**Consultation Response from KC,  
Highways Development Management**

**2024/92568 Land off, Manchester Road, Marsden, Huddersfield, HD7 6NJ**

**Erection of agricultural shed including access and associated works**

**Date Responded: 9-1-2025.**

Block plan (1:500)

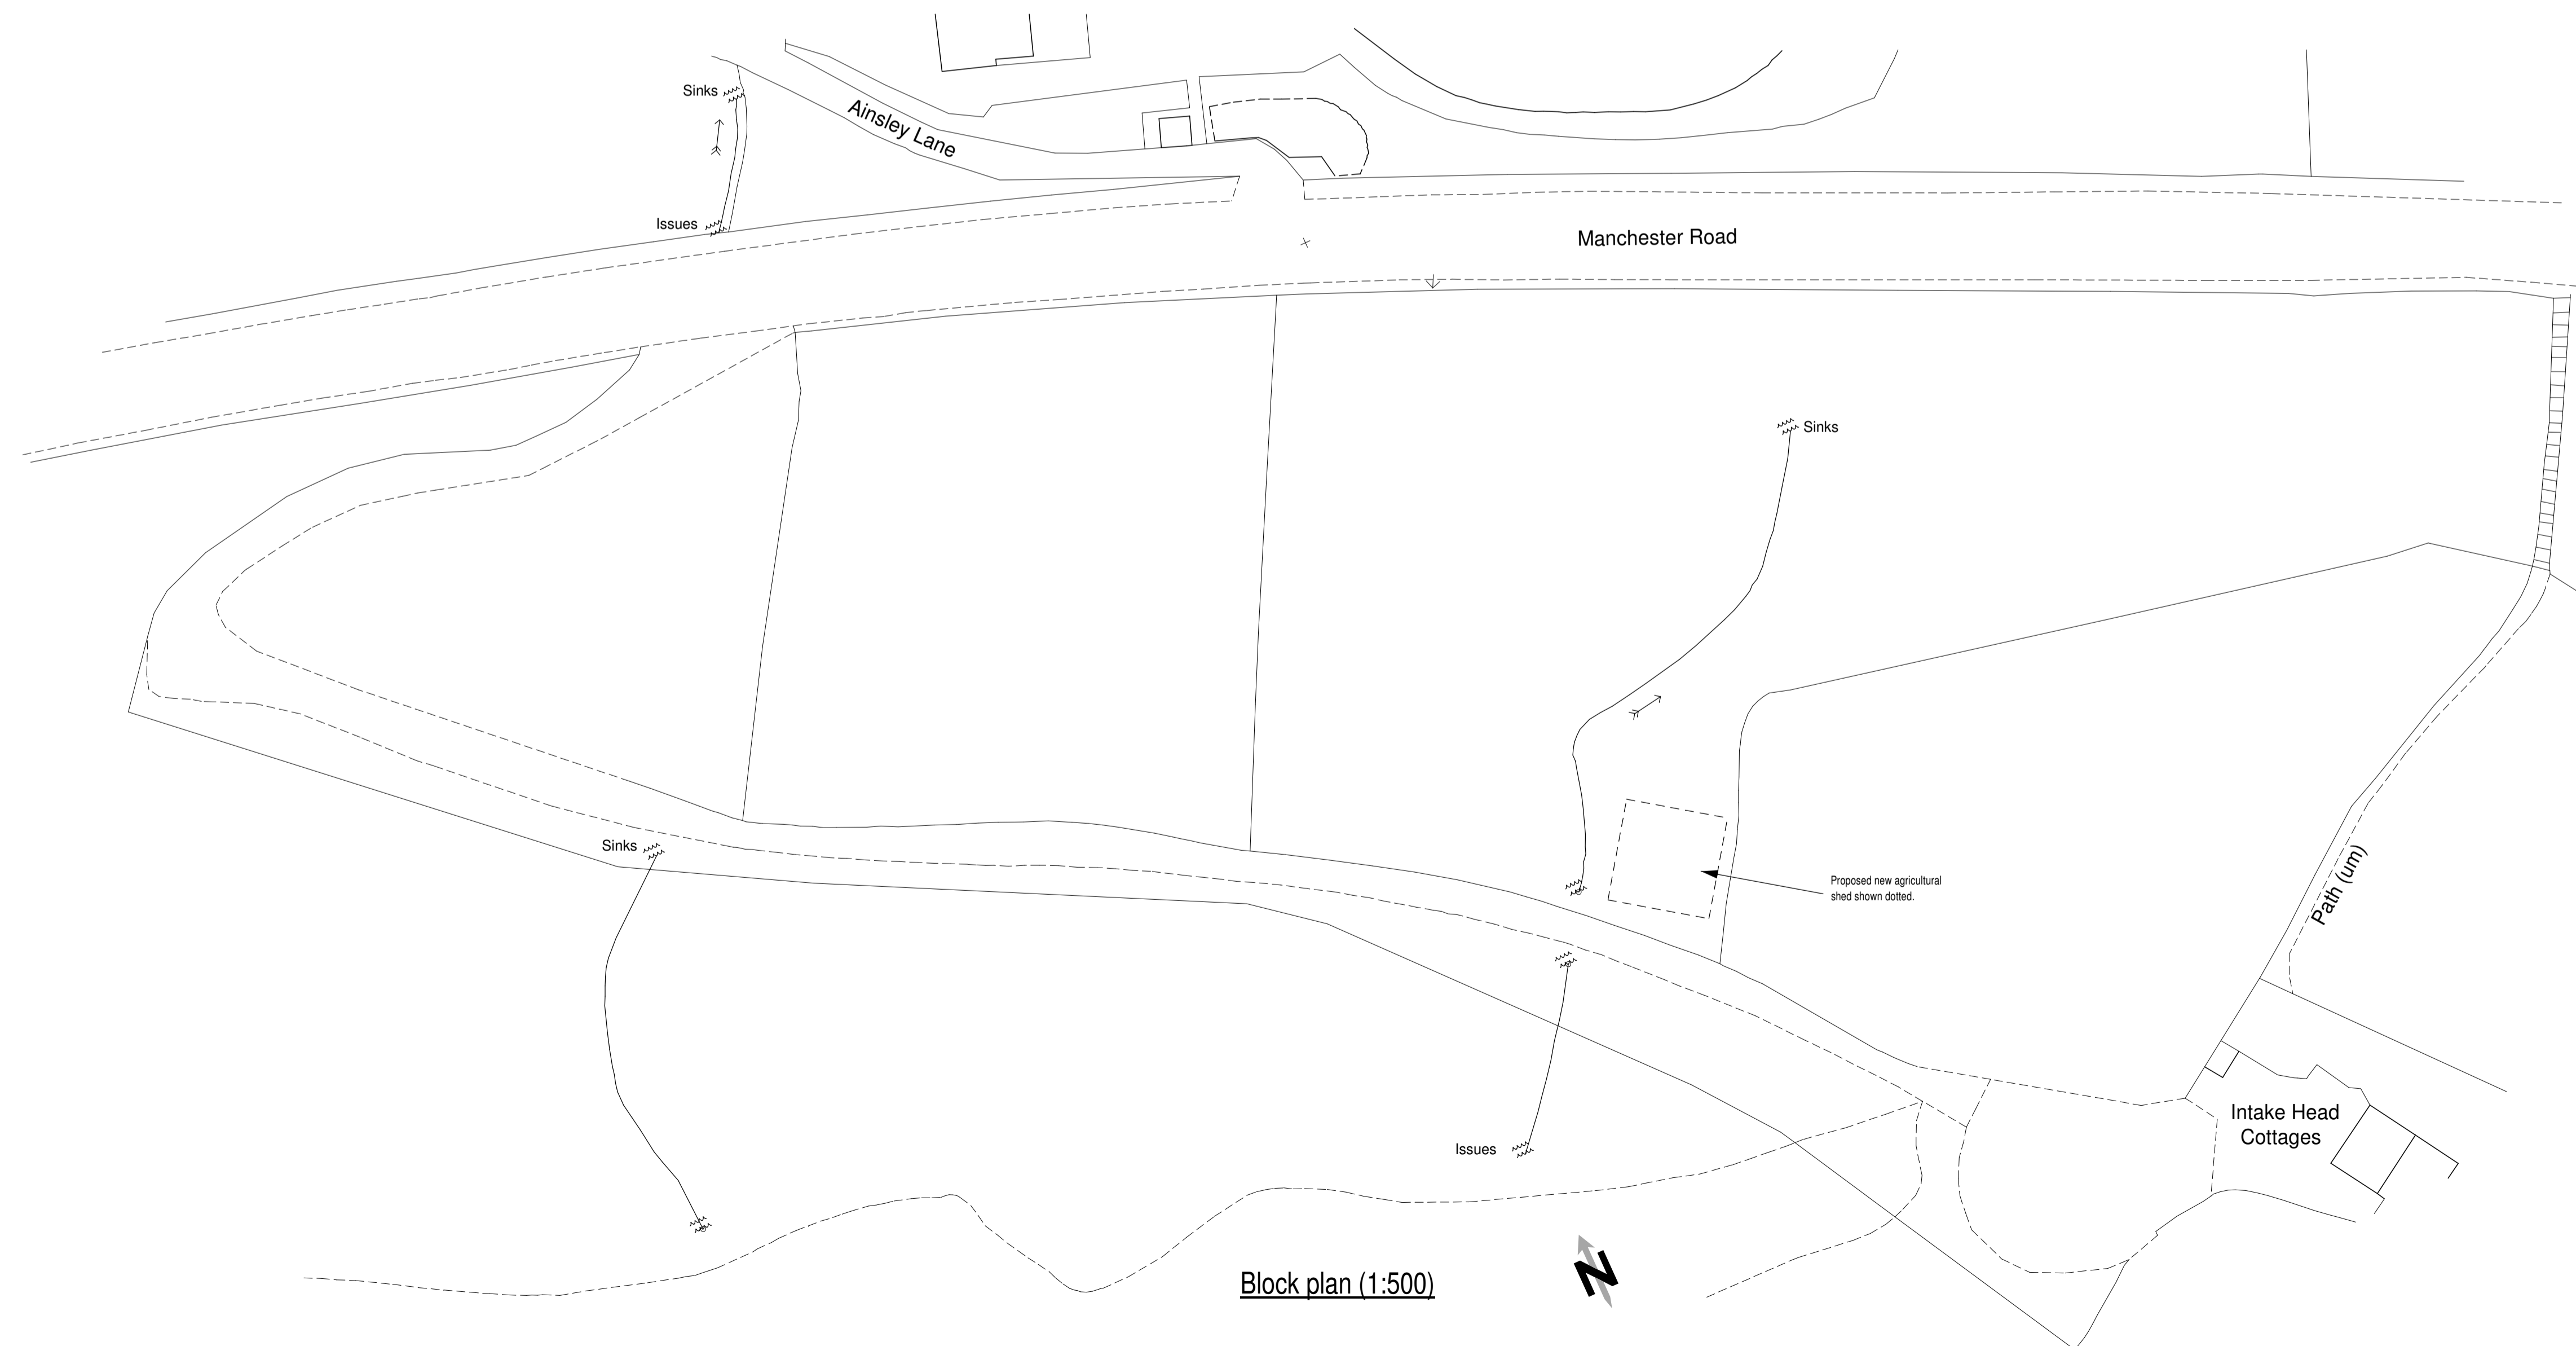
The application site is located on land to the south of the A61 Manchester Road. Access to the land is via an existing track from Manchester Road. The speed limit along this section of Manchester Road is 60 mph.

The existing access track is severely sub-standard in terms of its width, alignment onto Manchester Road and gradient. Sight lines from this access onto Manchester Road are also severely sub-standard.

The existing access from Manchester Road is clearly not suitable for any further intensification in use.

Unless the applicants can confirm that this proposal will not result in any further intensification in use of the access from Manchester Road this application should be refused on highway safety grounds.
